The Issues Associated with the Design of the Proposed Relocation of the Berry Equestrian Centre

This submission concerns the impact of the proposed Foxground and Berry Bypass on the Berry Equestrian Centre which is located in North Street Berry.

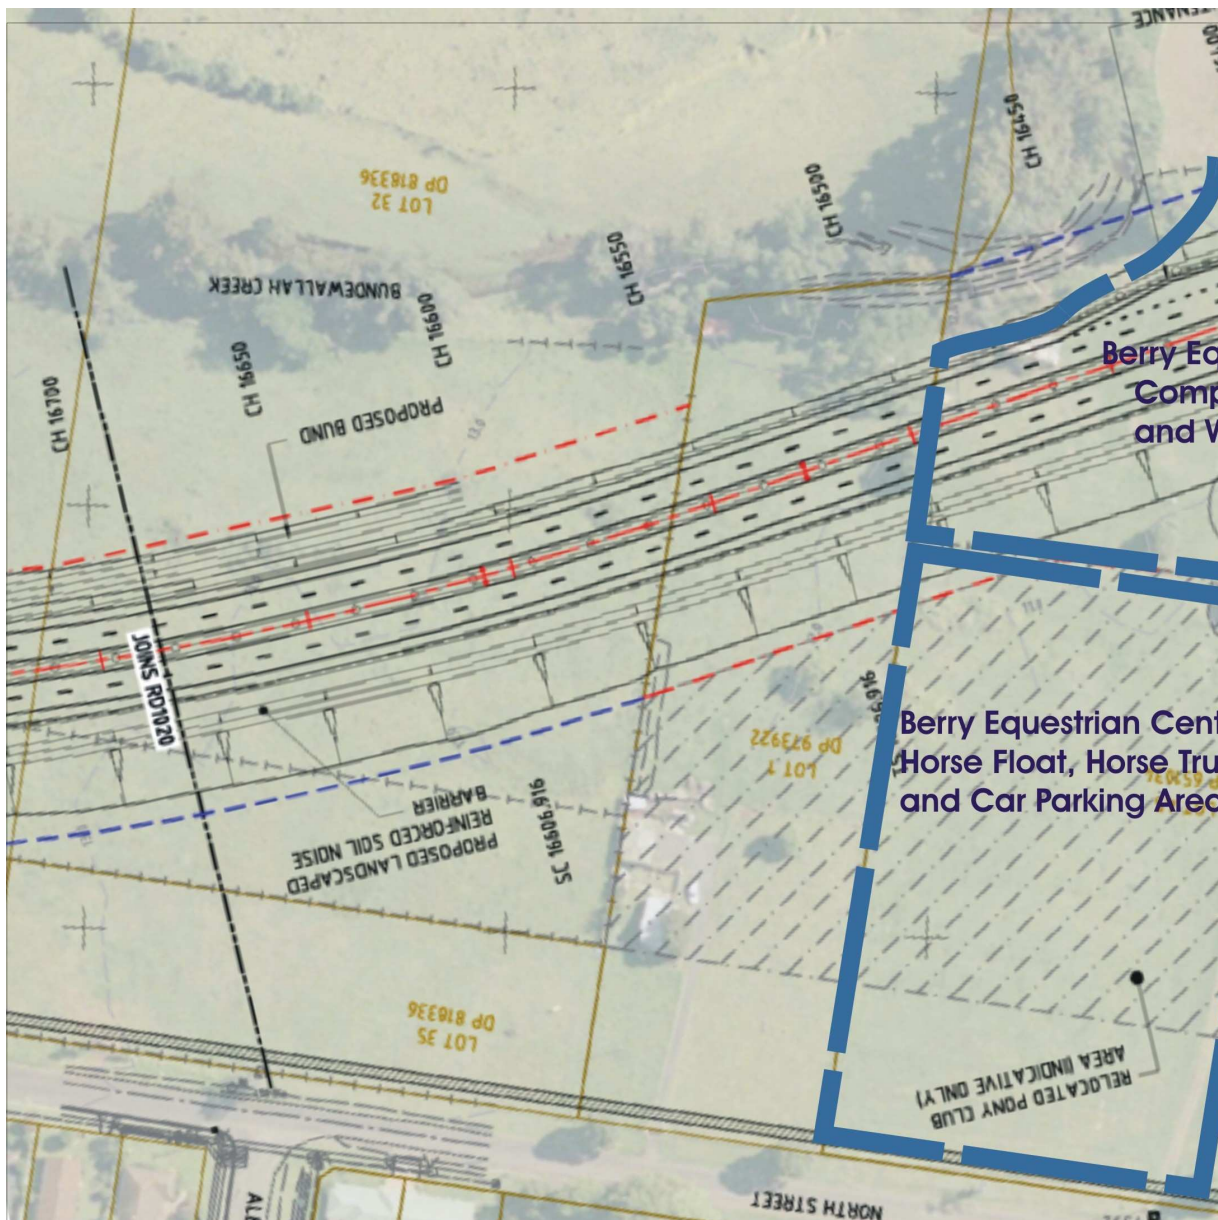
1. The competition grounds are required to be rectangular /square in shape of a minimum size of 140 metres x 140 metres with a level, well drained, good riding surface in order to cater for at least 4 dressage arenas or 2 showjumping arenas.

2. The parking area is required to be of a minimum area equivalent to 90 metres x 160 metres and allow for easy entry, maneuverability, parking and exit of horse floats and trucks. Each parking space is equivalent to an absolute minimum of 4 normal vehicle spaces due to the need for unloading/loading and tie up areas for horses.

3. There is concern for the safety of horses, riders and the general public due to the near location of the proposed riding area to the 4 lane expressway, the skateway, the public cycleway/walkway and North Street. There will be anticipated significantly increased noise and visibility of cars and trucks travelling at 100km/hour on the expressway with horses competing nearby, often with young, very inexperienced riders.

4. Access to the grounds is likely to be across a public shared cycleway/pathway. The safety of children on skateboards, bicycles etc are at risk as horse trucks and floats cross the pathway. Horse floats and trucks also require an indented driveway of at least 15 metres to allow vehicles to park off the roadway whilst gates to the grounds are opened.
